## ASSESSMENT REPORT

### MIXED USE DEVELOPMENT, EASTLAKES SHOPPING CENTRE MP 09\_0146 MOD 2

DRAWING TITLE
**CONSTRUCTION PLATFORM
VEHICLE TURNING PATH**

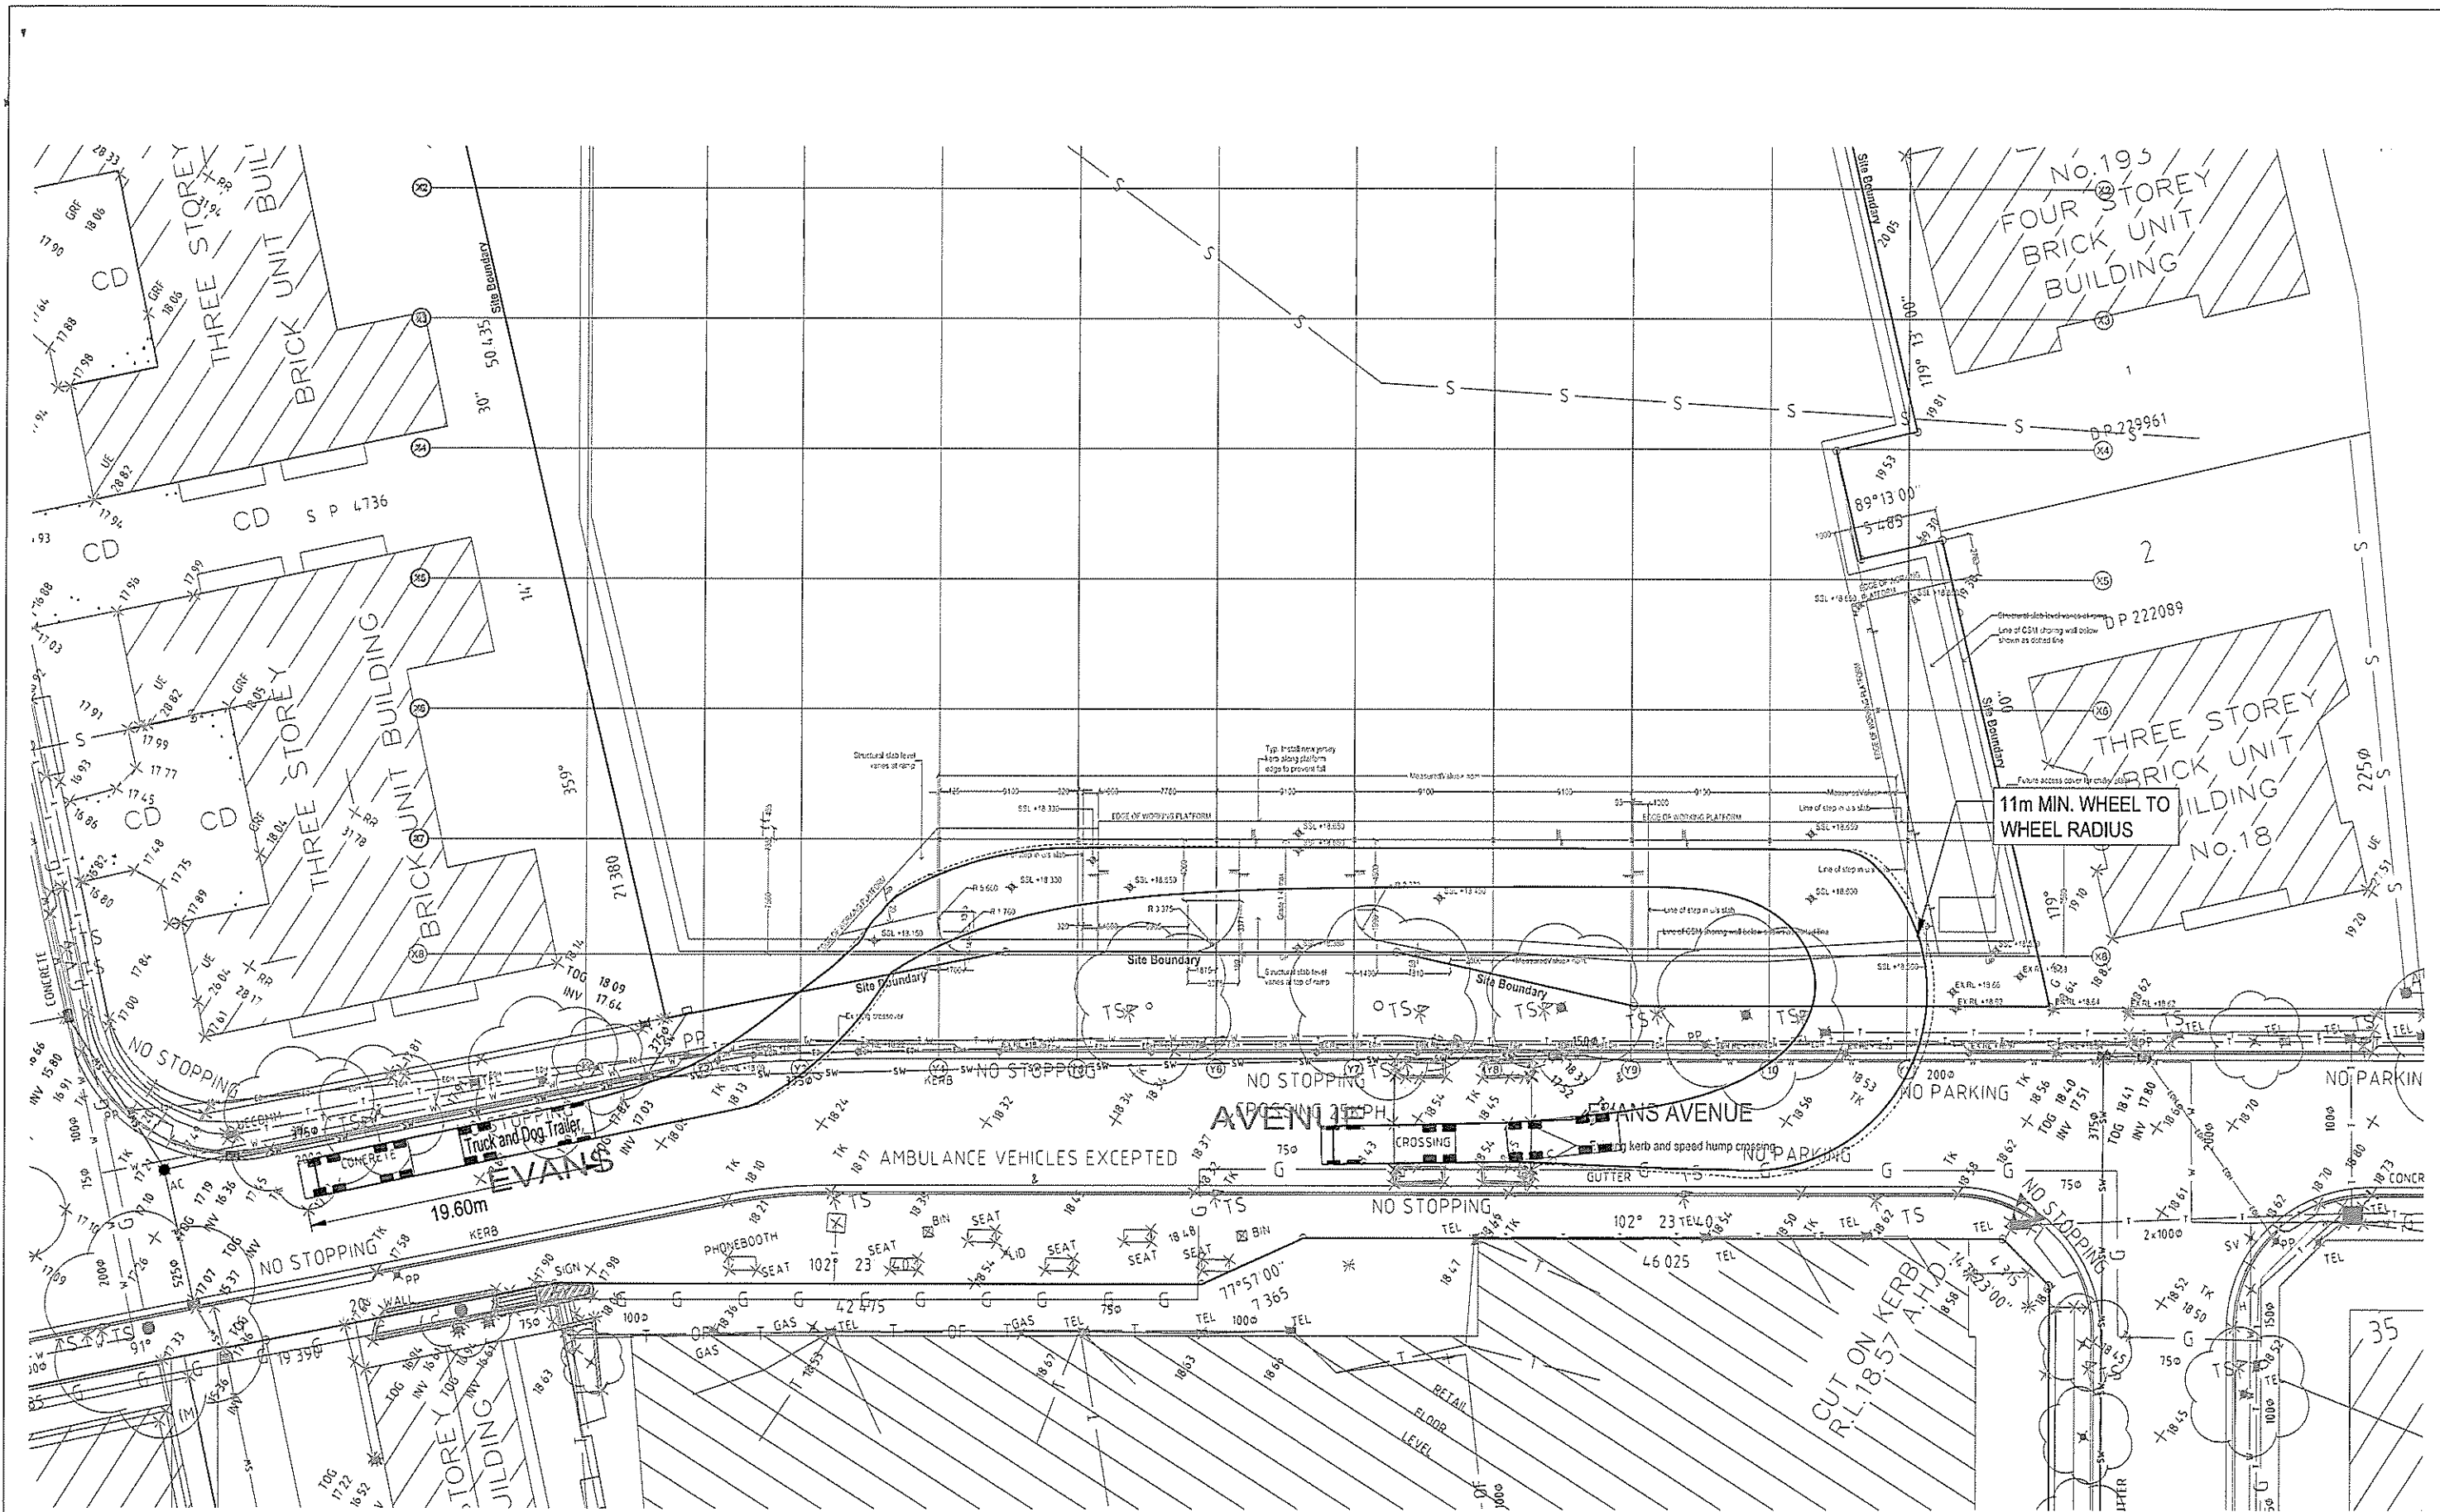
**Council** requested an additional swept path analysis for the Gardeners Road and Racecourse Place intersection and the Racecourse Place and Evans Avenue intersection. It also requested an investigation into the existing road pavement adequacy to cater for the largest proposed vehicles and design and reconstruction of the road pavement for the travel route in accordance with Austroads.

In response to Council's comments, the Proponent provided an additional swept path analysis for the intersections requested and design calculations in accordance with Austroads – Guide to Pavement Technology Part 2: Pavement Structural Design, 2012 showing the existing road pavement can cater for the 19 m long vehicles.

Council reviewed the analysis and advised it has no further comments regarding swept paths. However, it requested a dilapidation report be provided for all traffic facilities along Racecourse Place and Evans Avenue.
